# **Little Crow Solar Park**

## **Examining Authority's (ExA) Consultation on the draft Development Consent Order (DCO)**

**Schedule of ExA's recommended amendments to the Applicant's  
draft DCO version F [REP6-003]**

**Issued on 1 September 2021**

Figure 9 Extract from Work Details – Proposed Temporary Diversion of Footpath 214 (2.39LC DRW)

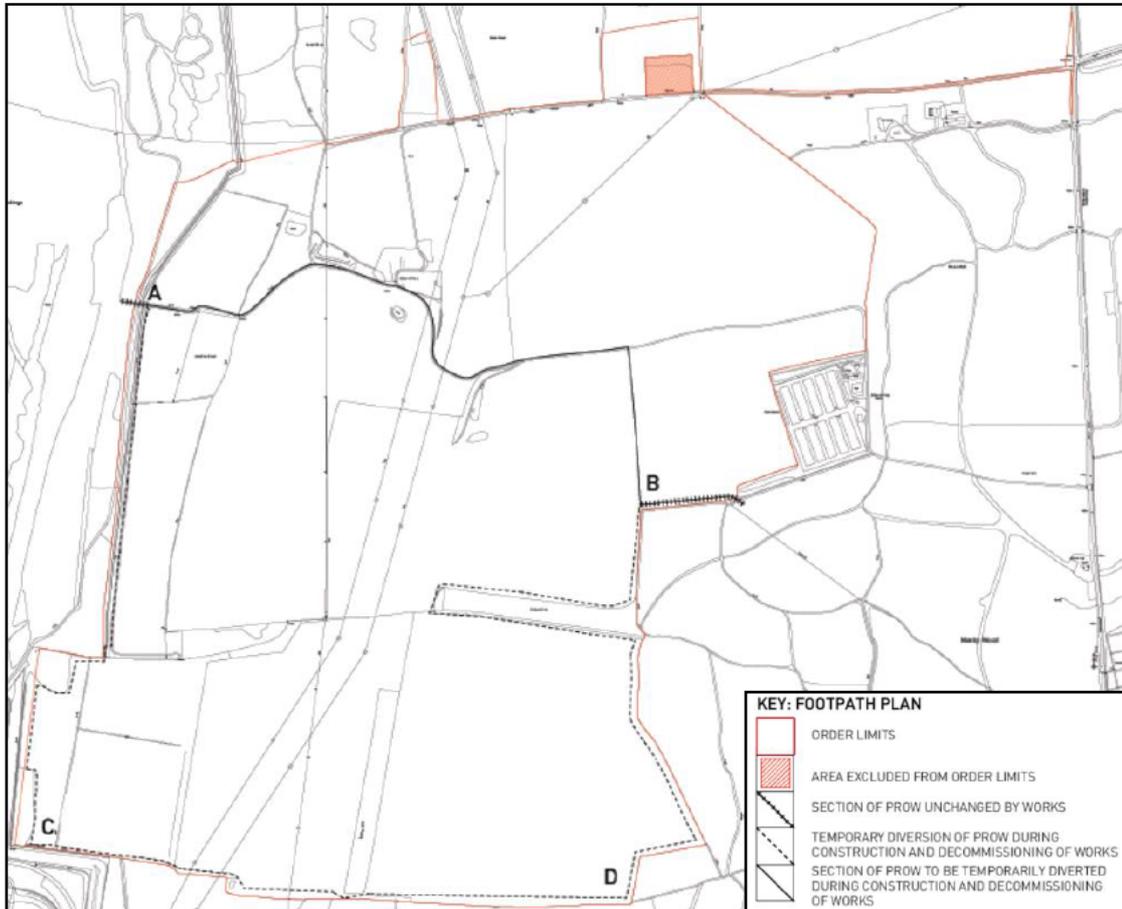
<p>used in no other part of the draft DCO.</p> <p>With respect to sub-paragraph (10) the ExA considers that it would be unnecessary. That is because sub-paragraph (9) would make it clear that on appeal the 'appointed person's' decision would be 'final and binding' (unless a decision was subject to a successful claim for judicial review) and would form a part of the records relating to the authorised development kept by the local planning authority (North Lincolnshire Council).</p> <p>With respect to sub-paragraph (12) the ExA considers that the suggested wording would be more precise.</p>
<b>Schedule 3 Public footpath to be temporarily closed and diverted</b>		
Column 2 in Table 1	'Drawing P17-0718-30 <b>REV G 1</b> – PROW (document reference 2.39 LC DRW)	The version of the plan submitted by the Applicant with its application showing the proposed temporary diversion of

public footpath 214 appears to be a revision G 1 or G I rather than D [Examination reference APP-043 and application document 2.39]
Column 6 in Table 1	'From <del>A-D-C-B</del> <b>A-C-D-B</b> as shown with a dashed black line ...'	The letters C and D appear to have been transposed in Column 6 when compared with the lettering shown on the footpath diversion plan [APP-043].
